From: [Rodenbeck, Jay B.](#)
To: [Donna Bohannan](#); [Planning Development Review Services](#); [Biazar, Shahab](#)
Cc: [Ron Bohannan](#); [Amadeo Trujillo](#); [April Christie](#)
Subject: RE: [#2023024] 2023024 Playa Del Sur Maimi Rd Noise Study (PR-2023-008674)
Date: Monday, January 6, 2025 11:37:00 AM
Attachments: [PR-2023-008674 Comments 12-4-24.pdf](#)

The Preliminary Plat for PR-2023-008674 / SD-2024-00056 had the following conditions of approval which must be met:

**Plat for
Playa Del Sur
Being Comprised of
Portions of Tracts 308, 309 and
310, Unit 8, Town of Atrisco Grant
City of Albuquerque
Bernalillo County, New Mexico
January 2024**

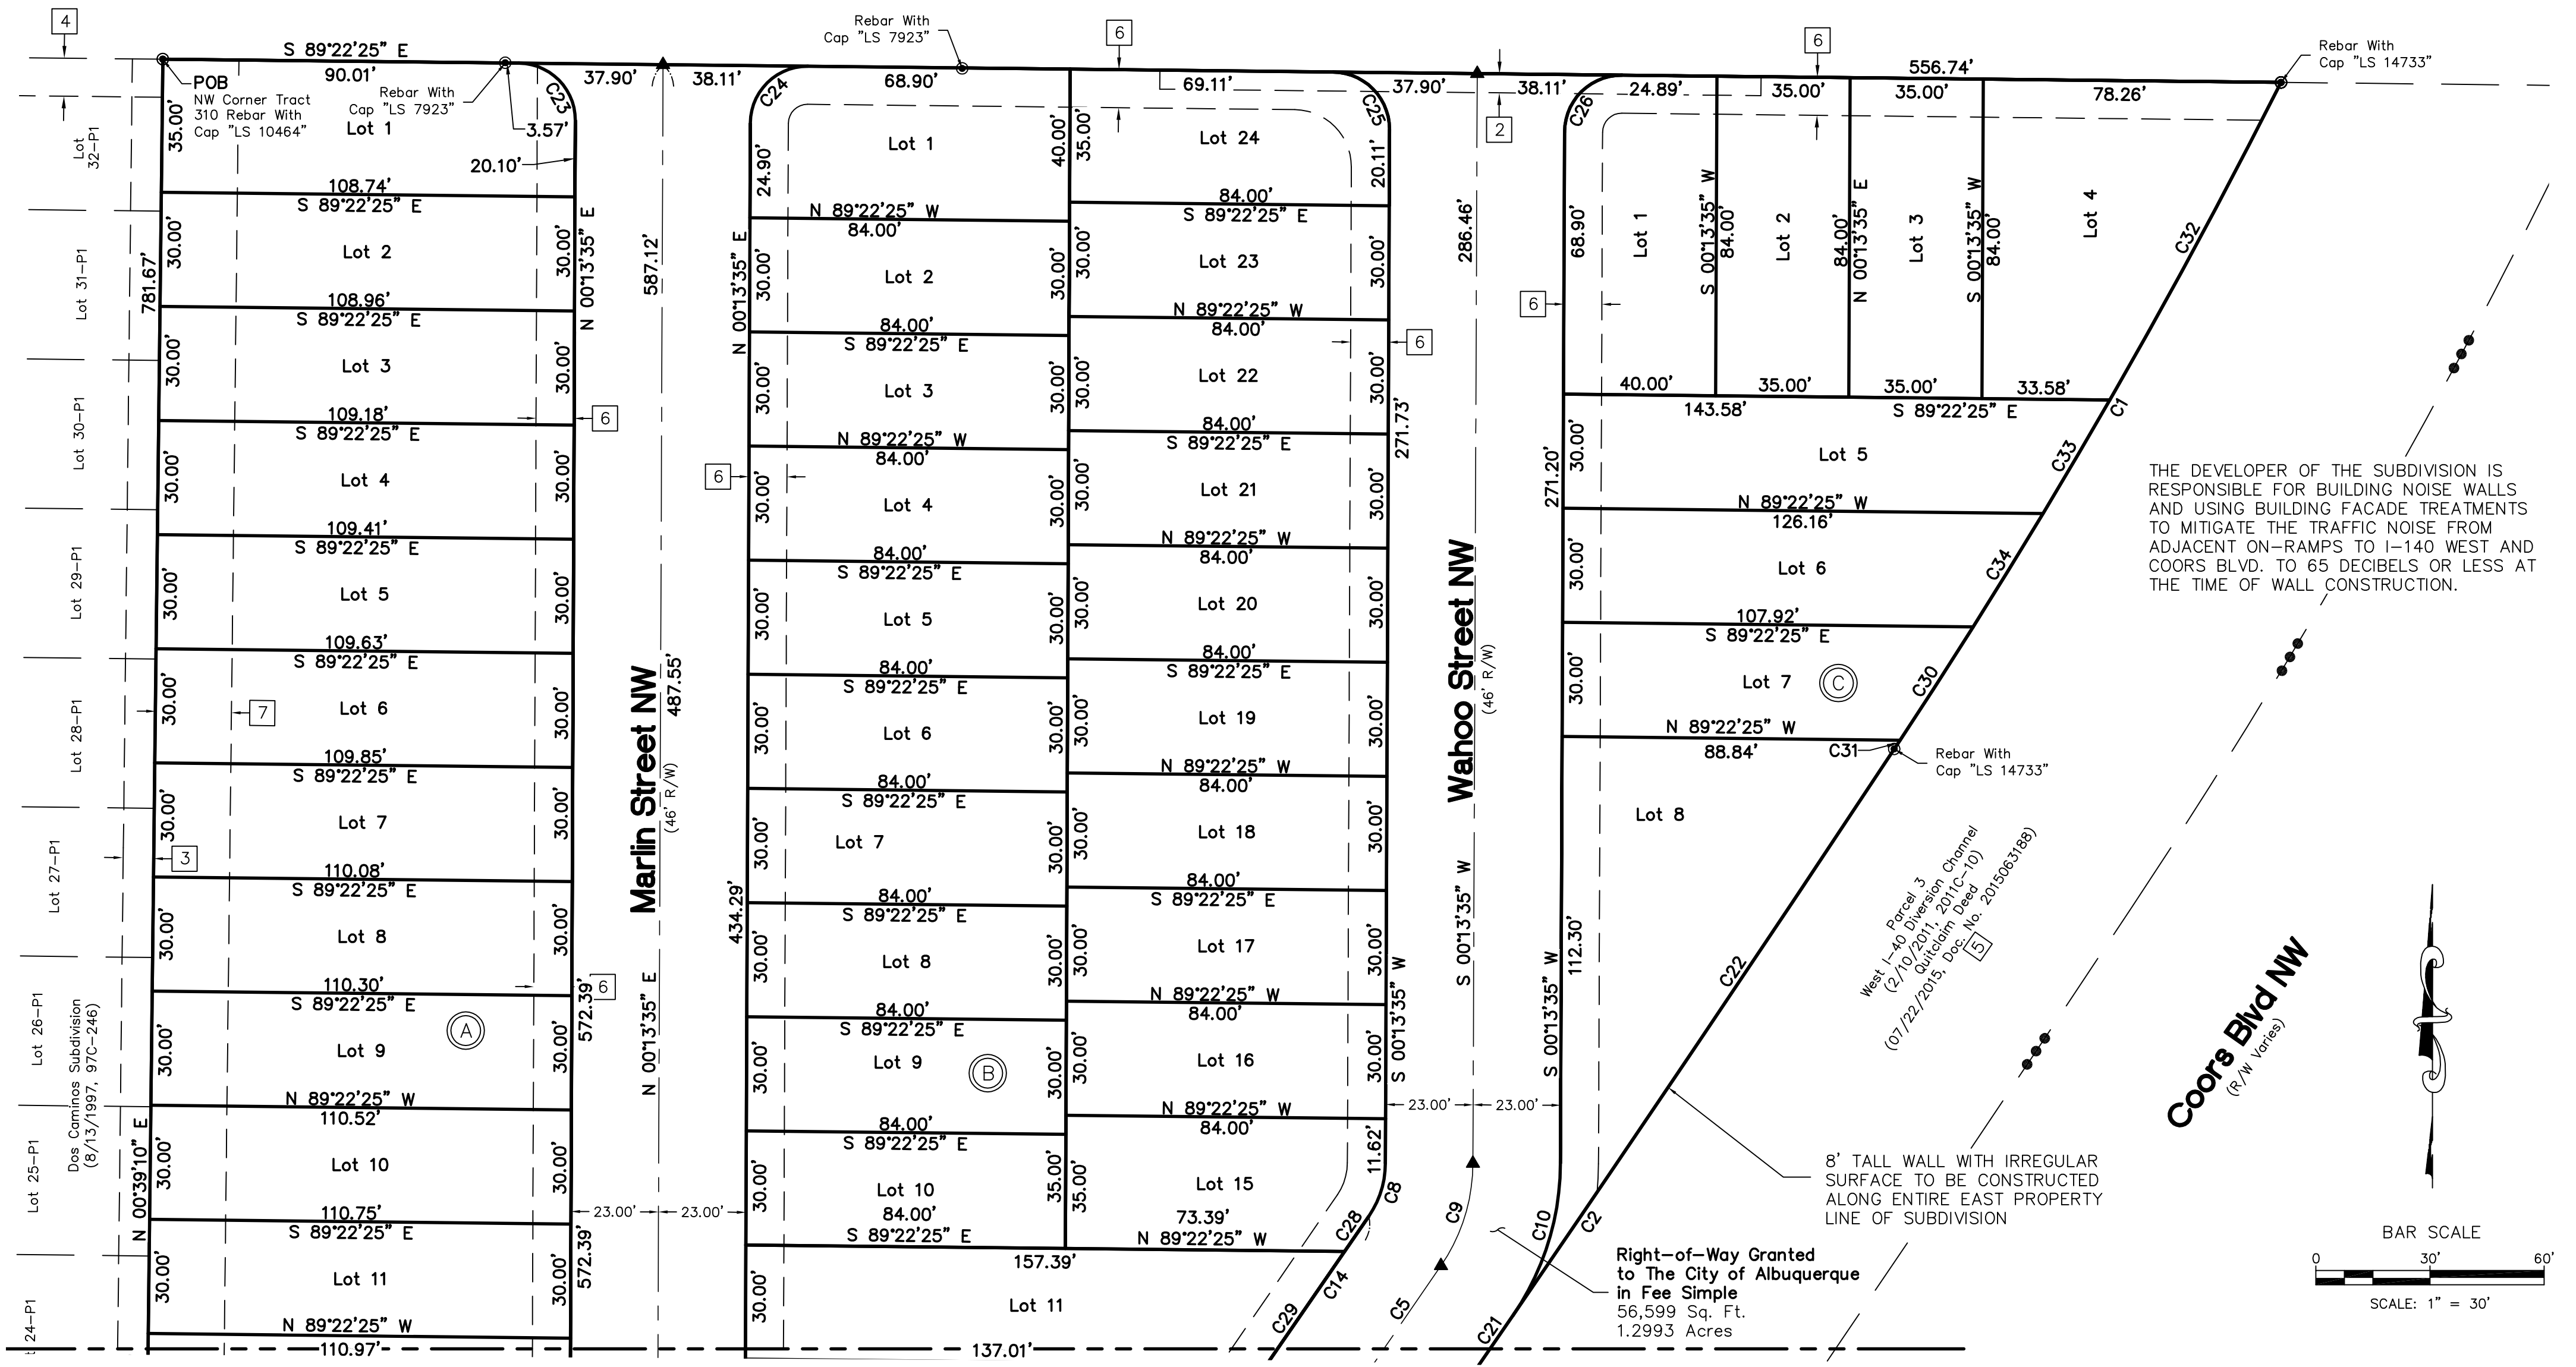
c. Show on the Plat that an 8-foot wall, no less than 6 inches wide, with an irregular, not flat, surface that bounces noise, possibly split face block, will be built along the entire eastern property boundary and to wrap around the corner with Lot 4 on Miami Road for a distance of 35-50 feet, stepping down as it approaches the front façade.

This condition is partially met with a label for this wall on Sheet 3. Please modify to the exact language above which includes 6 inches wide and the wrap around the corner with Lot 4 on Miami Road for a distance of 35-50 feet, stepping down as it approaches the front façade. This note must be added to Sheet 4 as well.

**8'-0" CMU CMU GARDEN WALL**

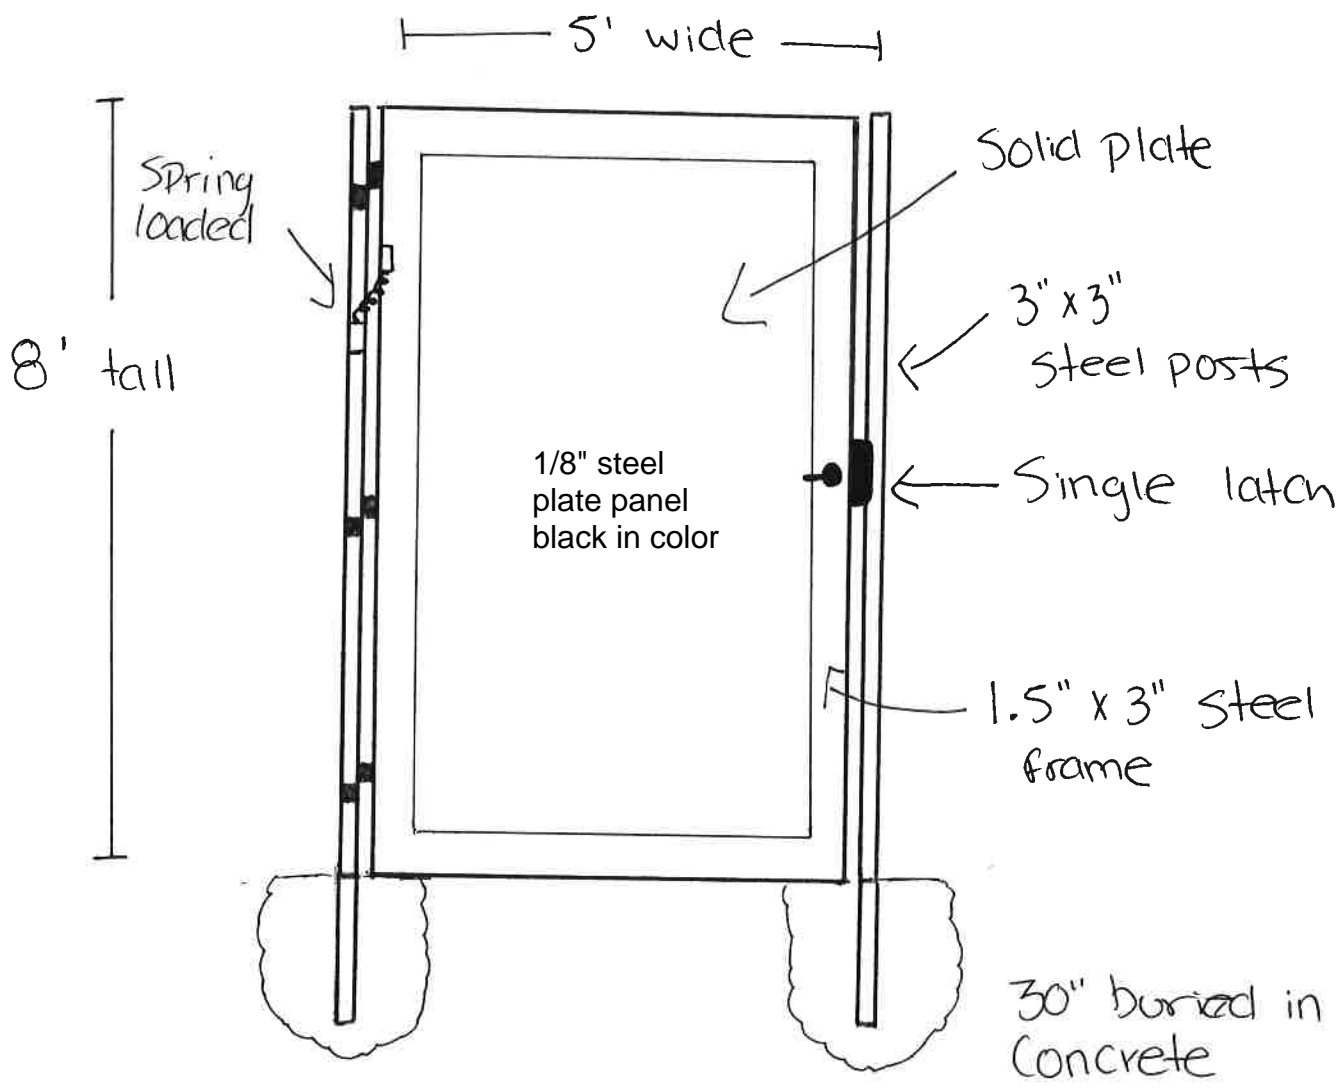
Confirm that the wall drawing on the wall permit document shows at least a 6-inchwide wall.
